SPACE VILLAGE FILING NO. 4
A PORTION OF THE NW 1/4 OF SEC. 17, T14S,
R65W, OF THE 6th P.M., EL PASO COUNTY, COLORADO
GRADING & EROSION CONTROL PLAN

SPACE VILLAGE FILING NO. 4
EL PASO COUNTY, CO

SHEET TITLE:
GRADING & EROSION CONTROL
COVER SHEET (SWMP-SITE MAP)

SHEET TITLE:  
**GRADING & EROSION CONTROL  
NOTES (SWMP-SITE MAP)**

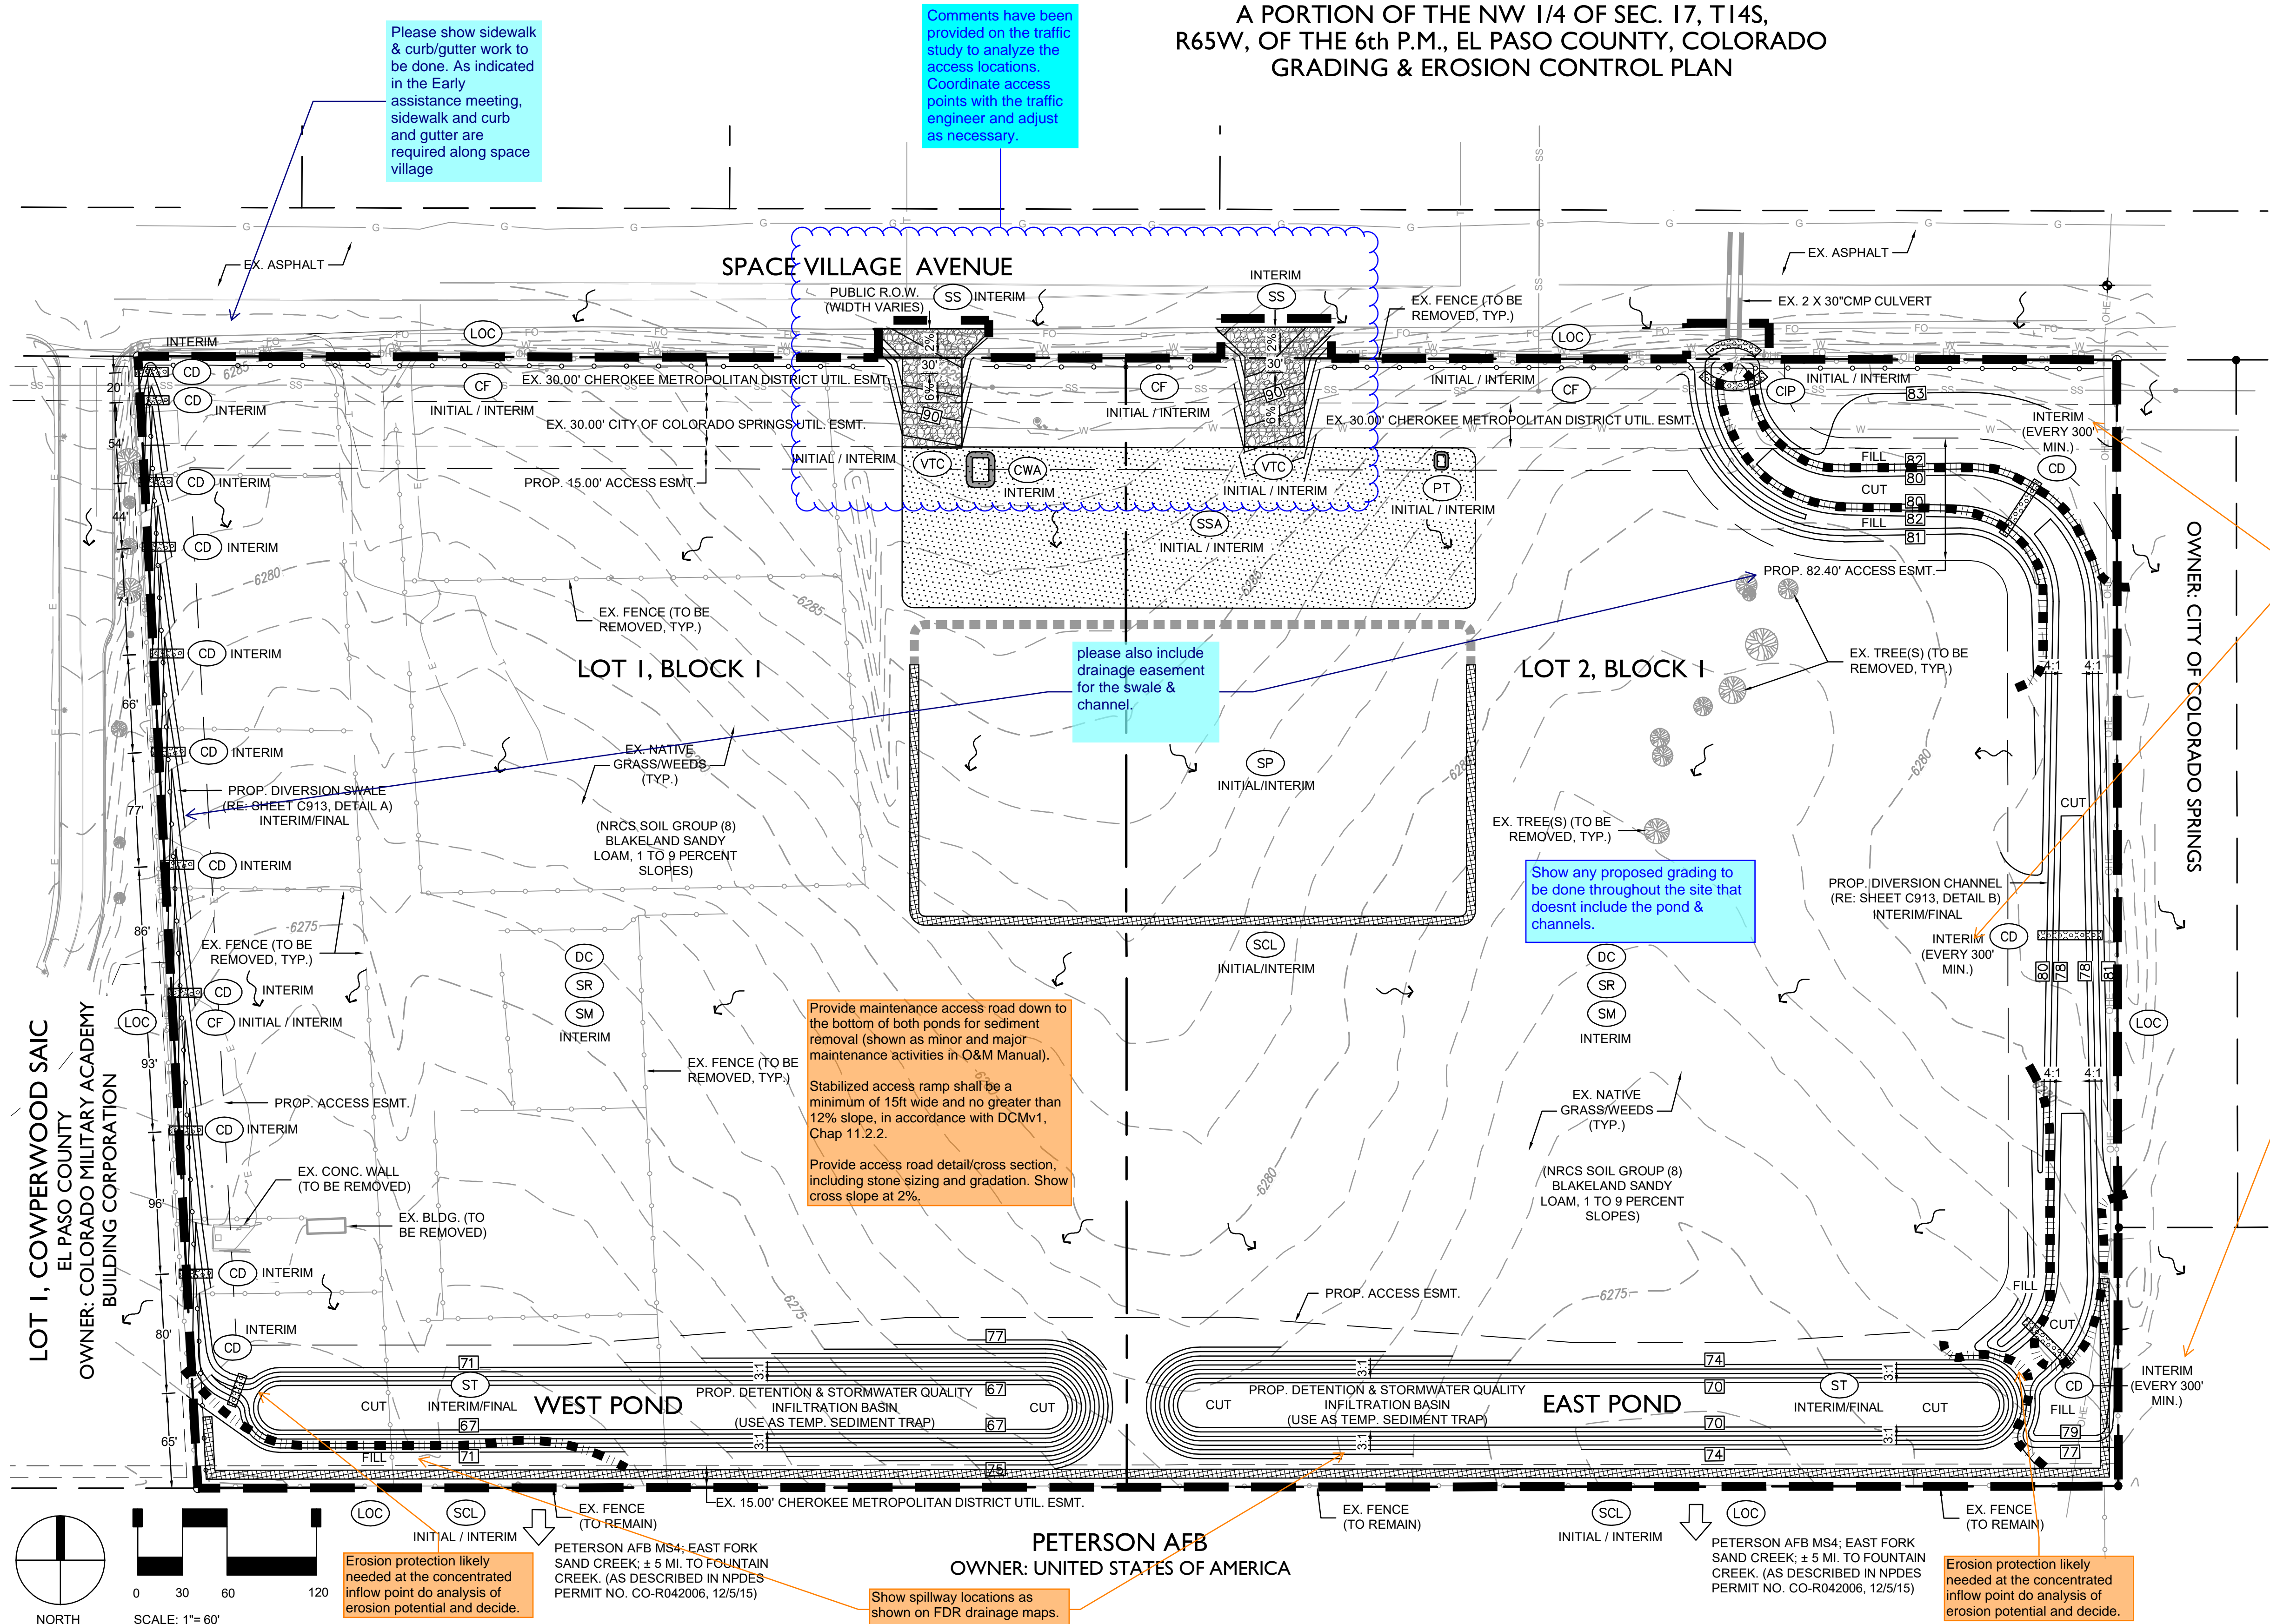
Please remove "El Paso County" from the heading on this page as these are not standard notes by El Paso County.
